# GEOLOGY AND SOILS REPORT and Wastewater Study with Detention Storage Criteria

**Redtail Ranch Subdivision**  
**Parcel No's: 5209002006, 5209002008, 5209000129 and 5209000128**  
**El Paso County, Colorado**

1  
C  
OVERALL PRELIMINARY PLAN

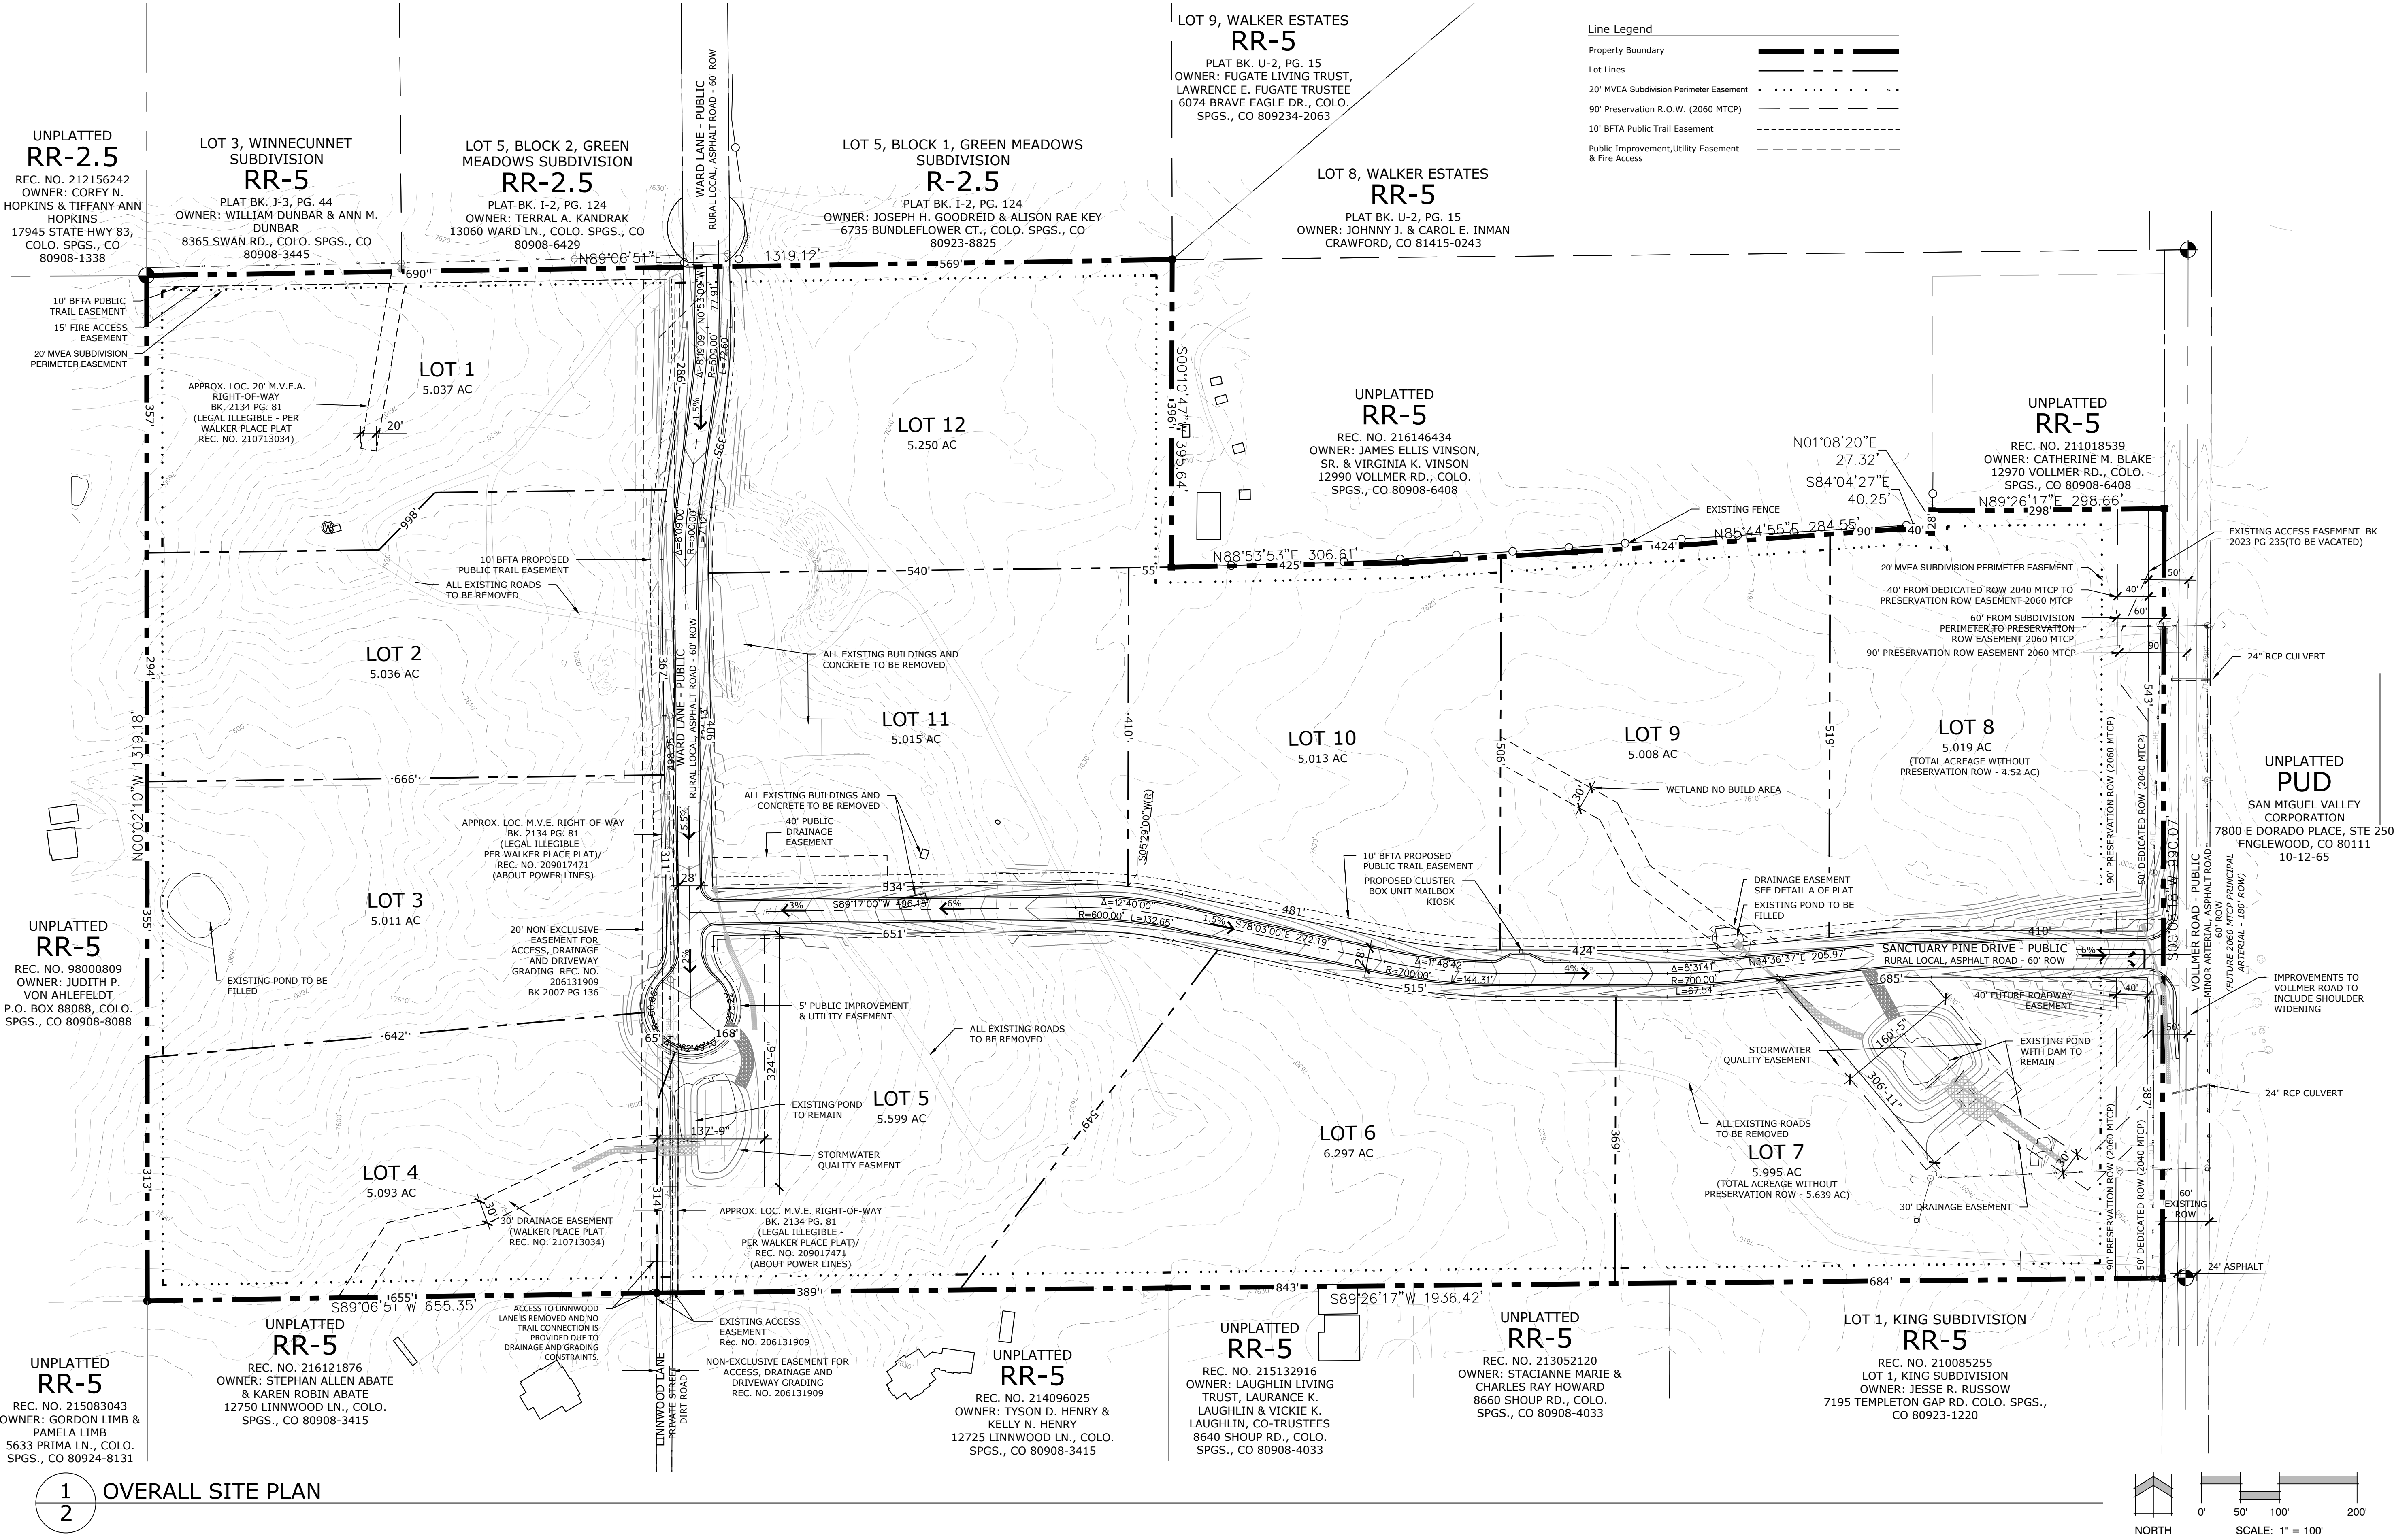
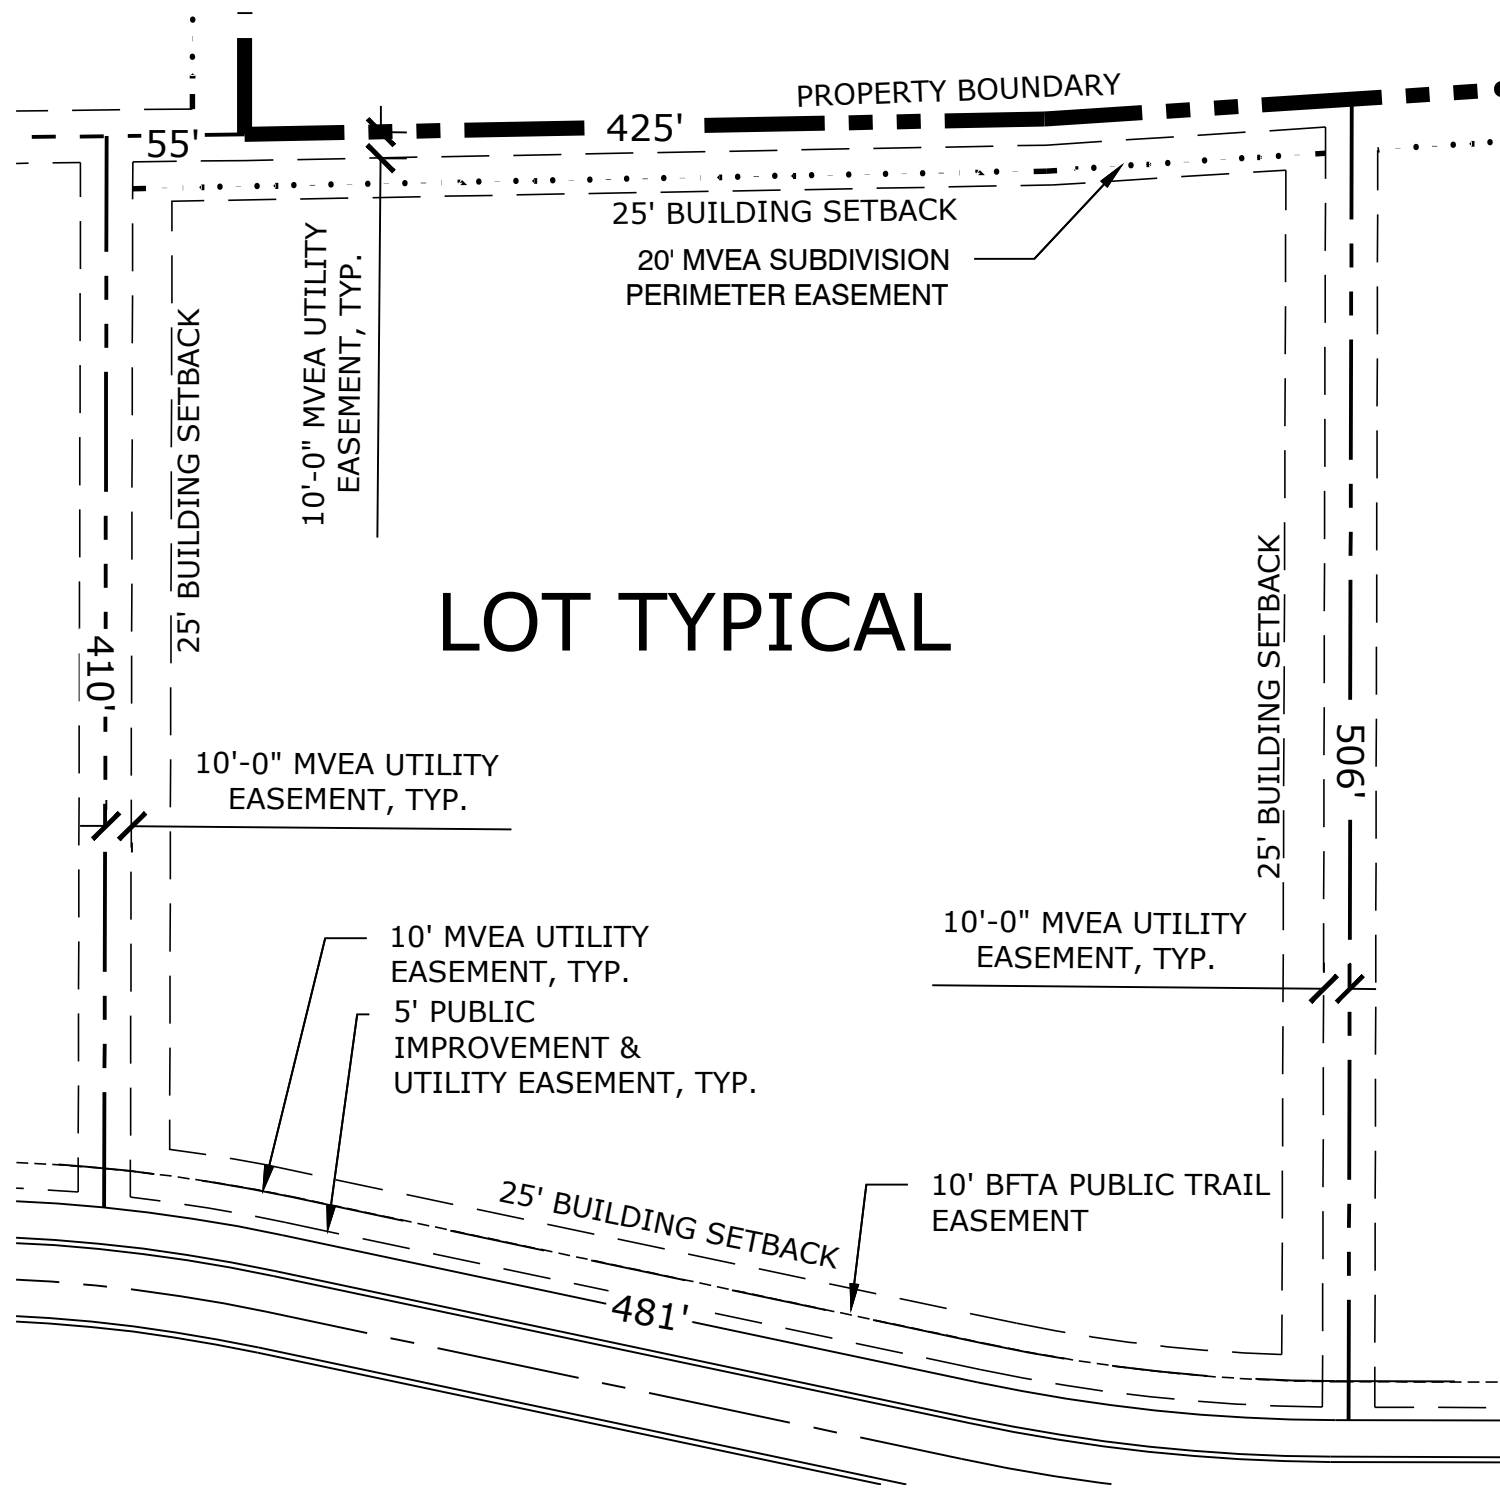
There are notable 2 drainage ways and at least 3 ponds that appear to have water intermittent and standing in them from the aerial maps. Most likely be a building constraint. These need to be addressed and identified so that they can be avoided or are you filling them in as mitigation? These comments are related to these sections (8.4.2. B & 8.4.5), 8.4.8 p-8-47 8.4.9 pages 8-52, 8-55

2 suitable septic systems per lot are to be identified.see page 8-47
